From: DEBORAH NORRIS 
Sent: 23 September 2014 20:44
To: Janice Chapman
Subject: Re: FP/132/14/HH - Car Port at 10 Grafton Avenue, Felpham

Subject : FP/132/14/HH - Car Port at 10 Grafton Avenue, Felpham

I am in the process of making a recommendation on the proposed car port. However, the s_ubmitted Block Plan 1:500 showing the car port when scaled measures 6m in length but the proposed drawings are annotated as 8m.

AREA 90m x 90m
SCALE: 1:500
CENTRE COORDINATES: 496417. , 100659.1
98

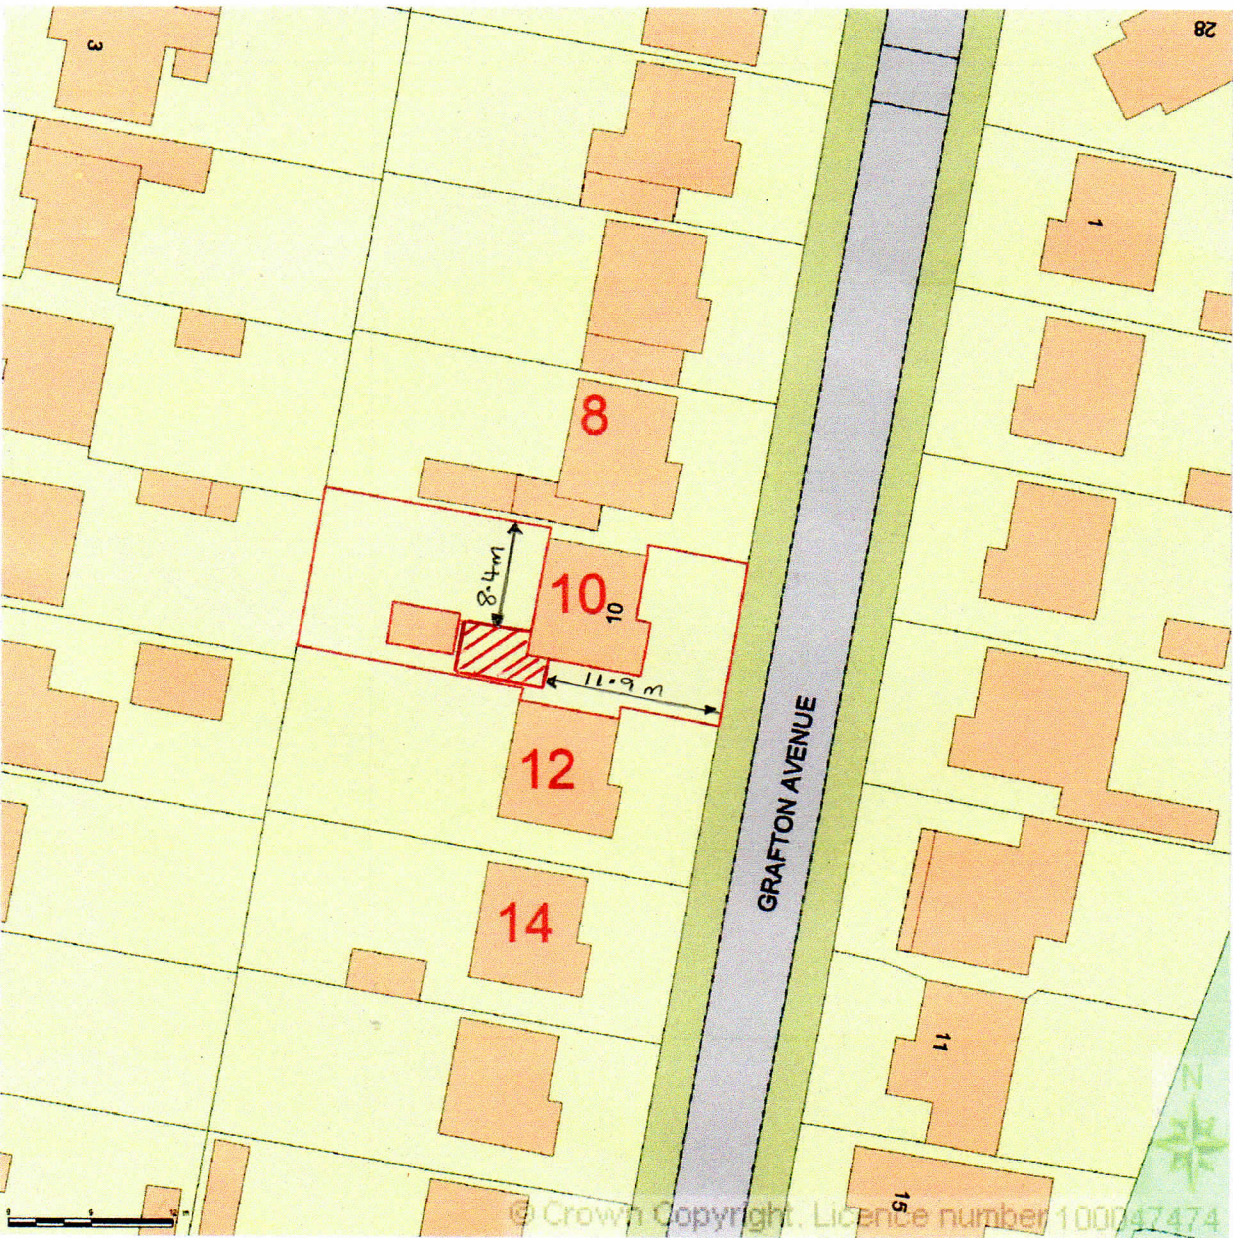
Please confirm and amend the Block Plan if this is not correct.

Dear Mrs Chapman

Please find attached the revised block plan as required, the original submitted block plan was drawn and sent back by my wife, as requested by Daun Johnson it was not mentioned that it needed to be to scale, just that it had to show the carport area so was done freehand.
